RE: GT Ranch (CU 14-00001)

RE: GT Ranch (CU 14-00001)

Kittitas County Community Development Services (CDS) is accepting Zoning Conditional Use (CU) and State Environmental Policy Act (SEPA) comments on a proposed gravel mine in the floodplain of the Yakima River near Thorp, Washington.

Wet lands

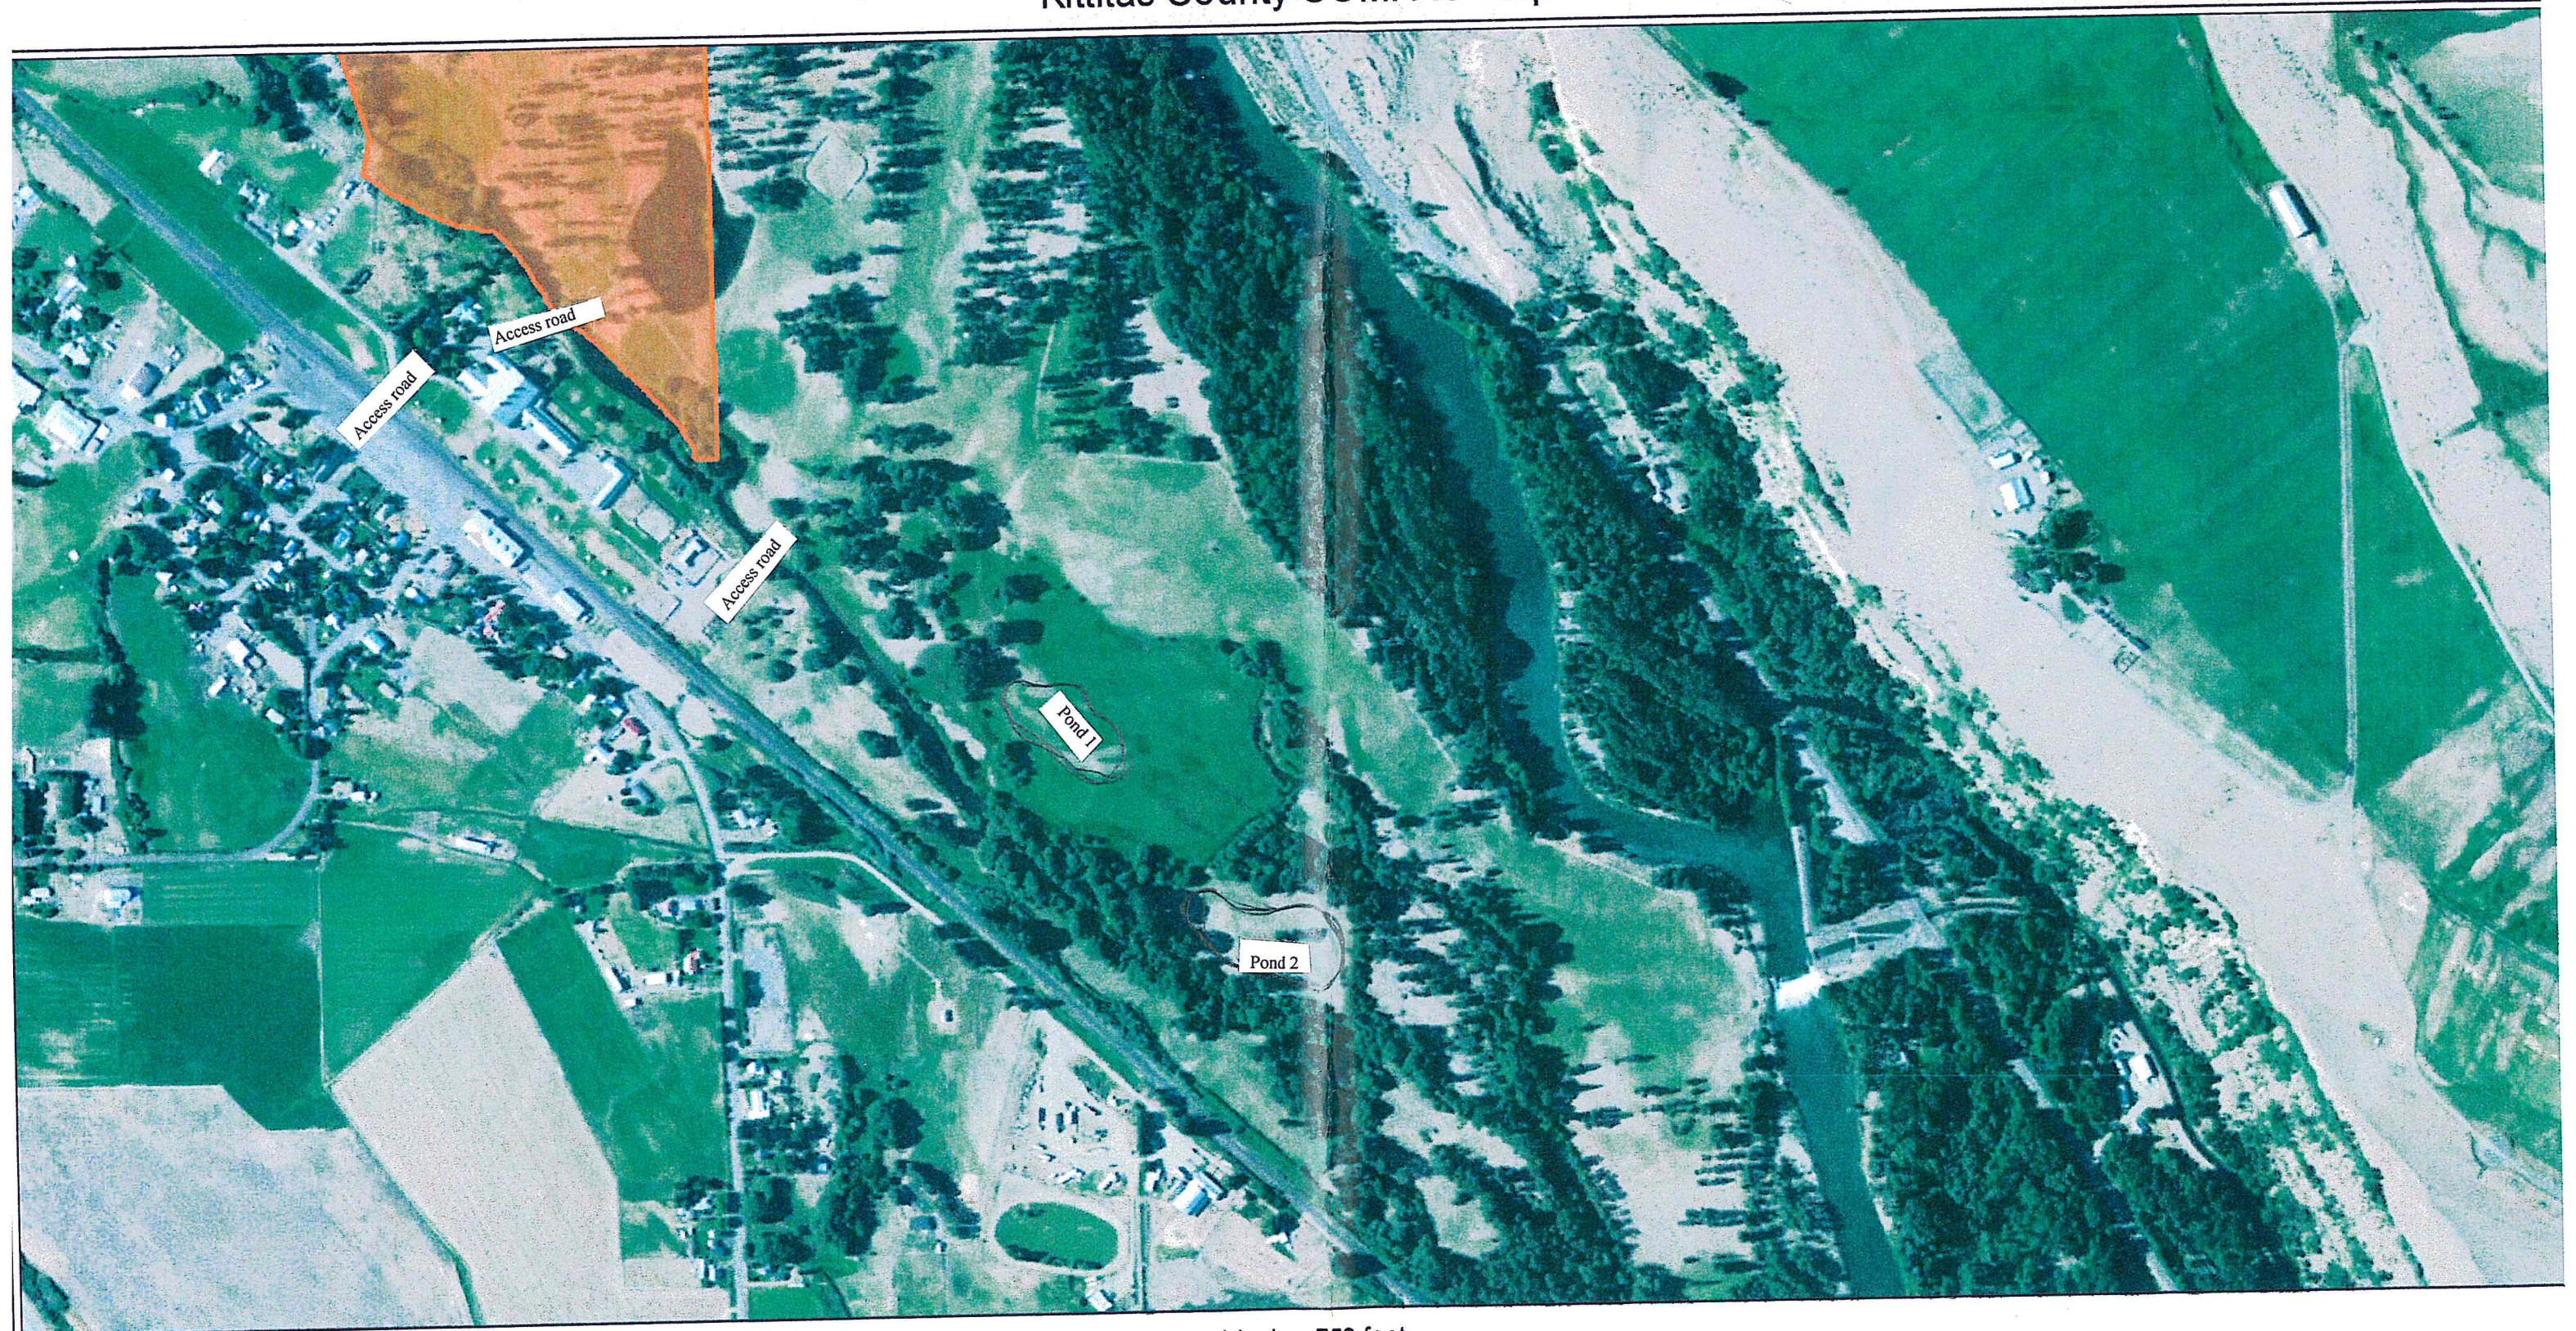
The floodplain within the project area contains numerous wetlands, including a long, linear wetland designated by the National Wetlands Inventory (NWI) directly south and west of the proposed mines. It also appears that the proposed pits may be within the buffer of such wetlands. A wetland delineation of the subject property should be required, so that wetland impacts can be assessed as part of the SEPA review. The linear wetland looks to be a side channel/spring book of the Yakima River. Side channels/spring books are a vital habitat component for all aquatic species. The ecological functions and values of the side channel/spring book should be assessed to ensure that all adverse impacts are properly mitigated.

B.3.a.2 It appears that the proposed mines are within the buffers of wetlands and side channels/spring brooks. A delineation and assessment of ecological functions is necessary to determine impacts and develop mitigation.

# GT Ranch Floodway and Floodplain

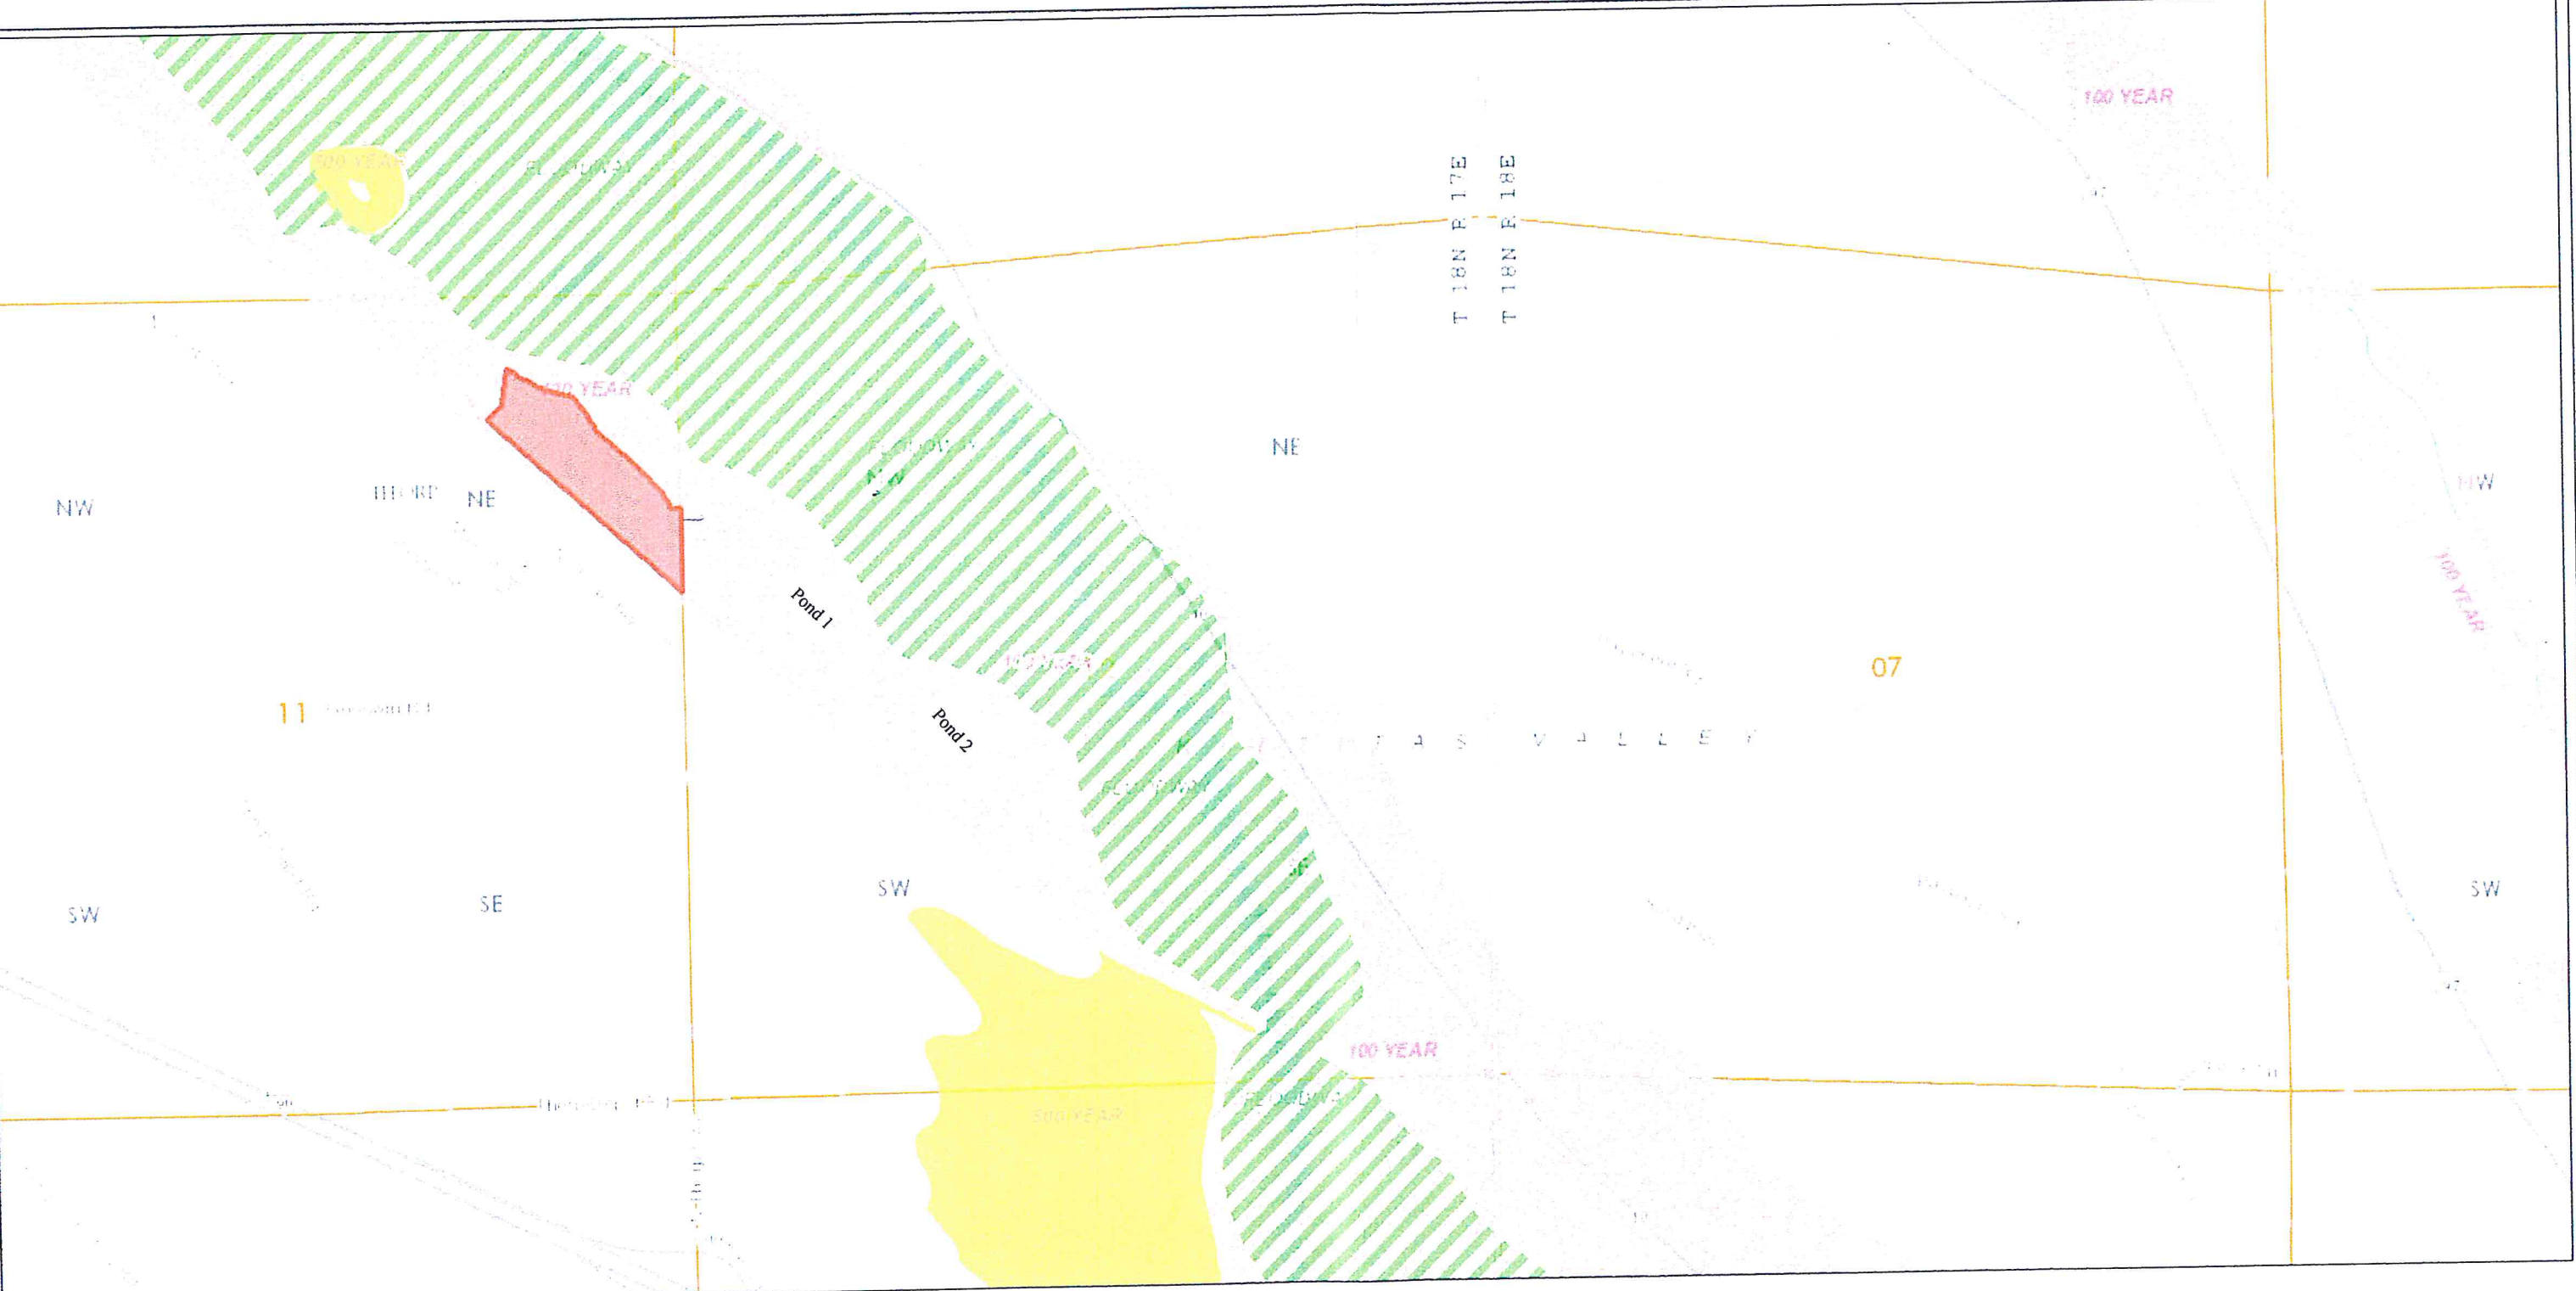
The proposed mining is within the floodplain of the Yakima River. The Inventory and Characterization Report (ICR) compiled for the SMP update includes several studies contracted by the U.S. Bureau of Reclamation collectively known as the "Reaches Report" (Snyder et. al. (2001), Eitemiller et. al. (2001), and Stanford et. al. (2002)). The Reaches Report was specifically contracted to determine ecosystem-wide functions present in the Yakima River Basin for anadromous fish restoration, and is considered the seminal science concerning the Yakima River and its floodplains. Snyder et. al. (2001) concluded that a significant amount of physical habitat remains in the five floodplain reaches of the mainstem Yakima River (Cle Elum, Kittitas, Selah, Union Gap, and Toppenish) because habitat-structuring floods still occur on the remaining expanses of floodplain environment. The major findings of Stanford et. al. (2002) can be summarized as:

# Pond 1

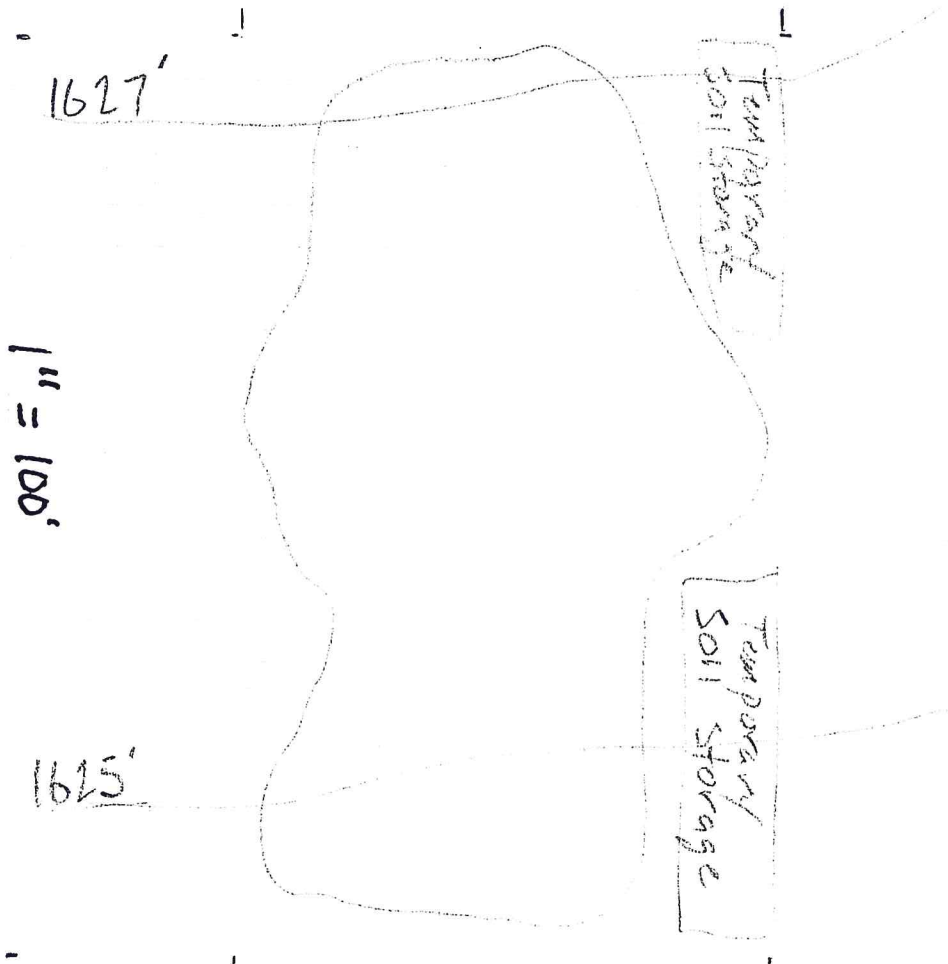
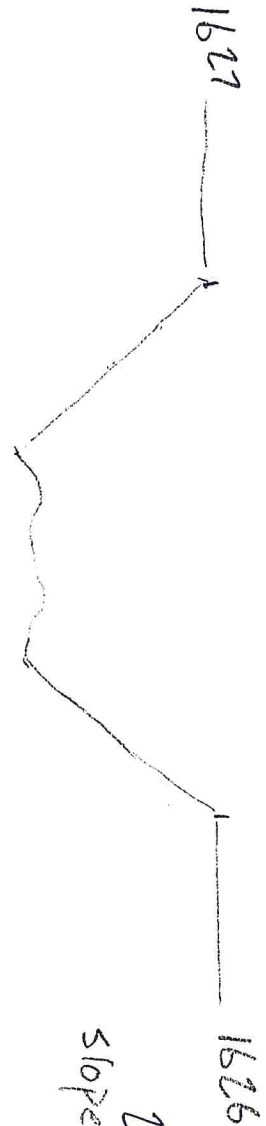
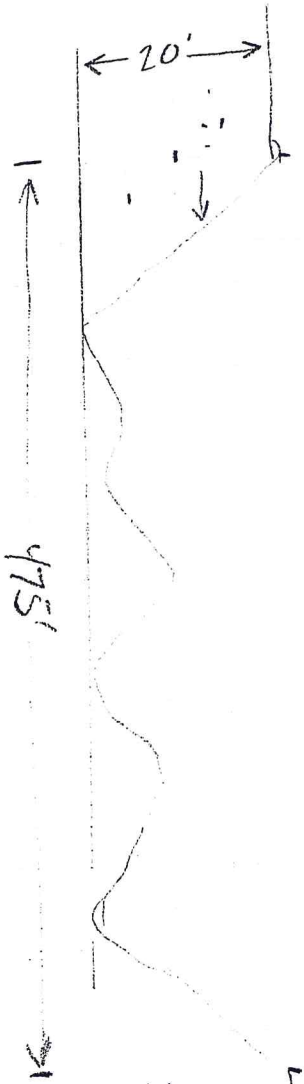
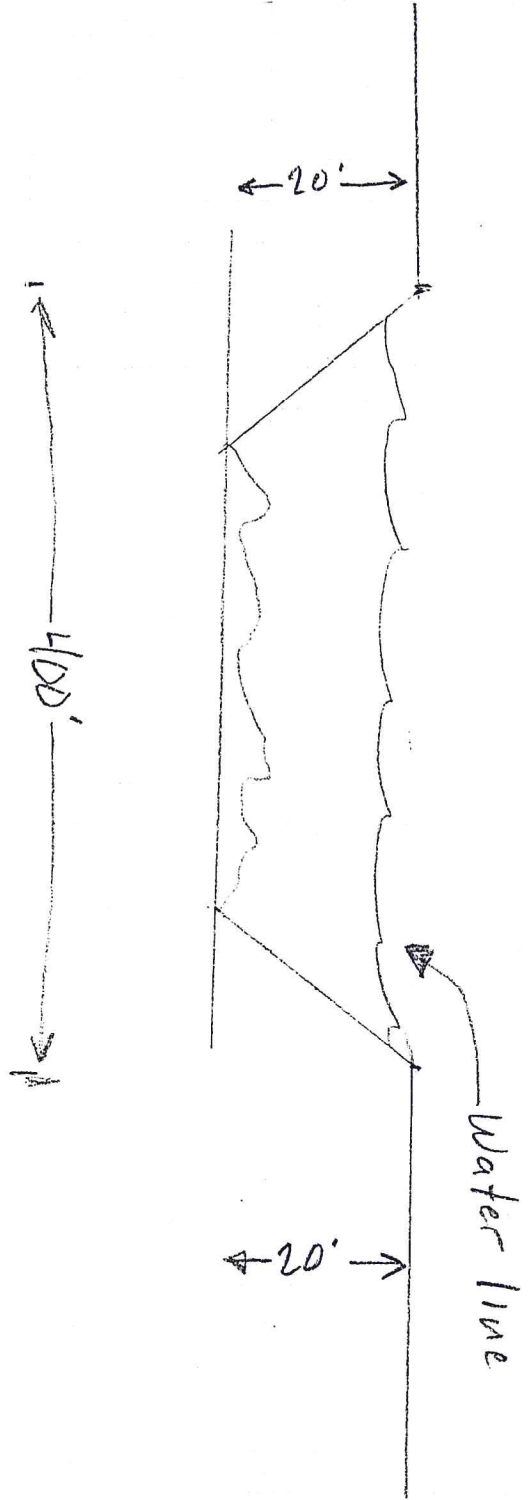
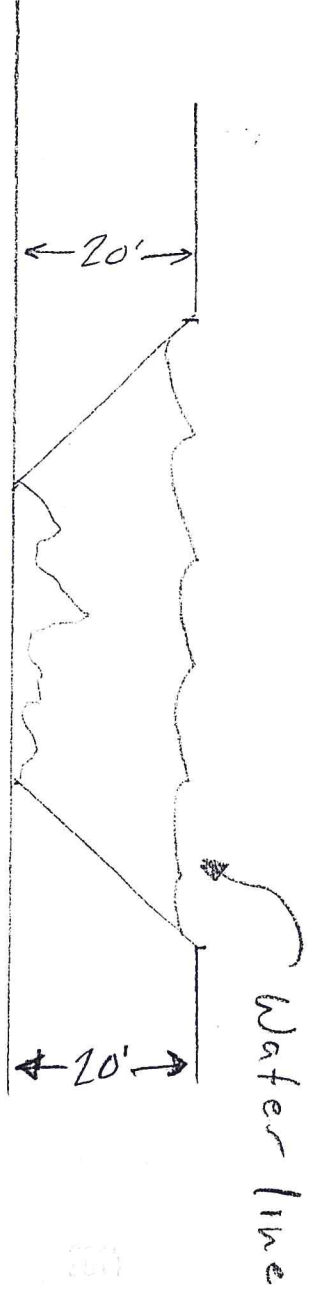
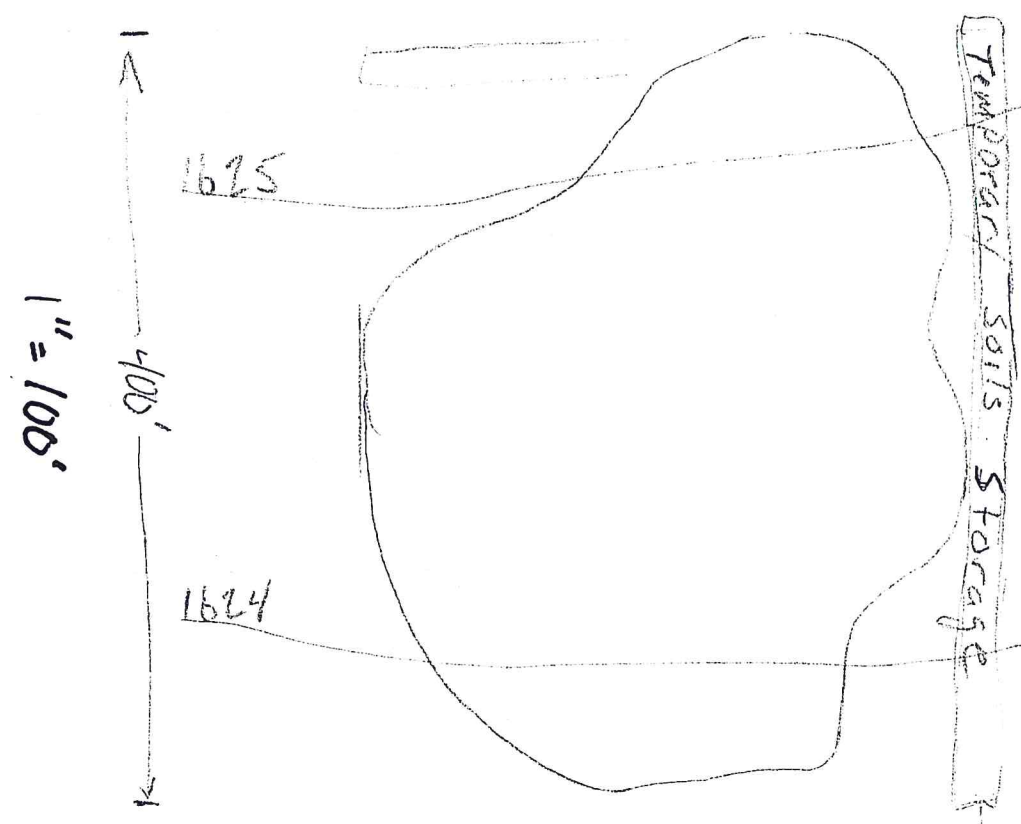
1. Mining process?
2. Stockpiling onsite?
3. Depth of mines?
4. How will the mines be dewatered during mining?
5. Depth to groundwater?
6. What is the haul route?
7. Reclamation?

A.10. Two 3 acres ponds, plus associated areas (haul route, equipment storage, stockpiles, etc) will require a Surface Mining Reclamation permit from the Washington Department of Natural Resources, per RCW 78.44 and WAC 332-18.

B.3.a.4, 6/B.3.b.1 Will the mines be dewatered during mining? If so, that constitutes a withdrawal.
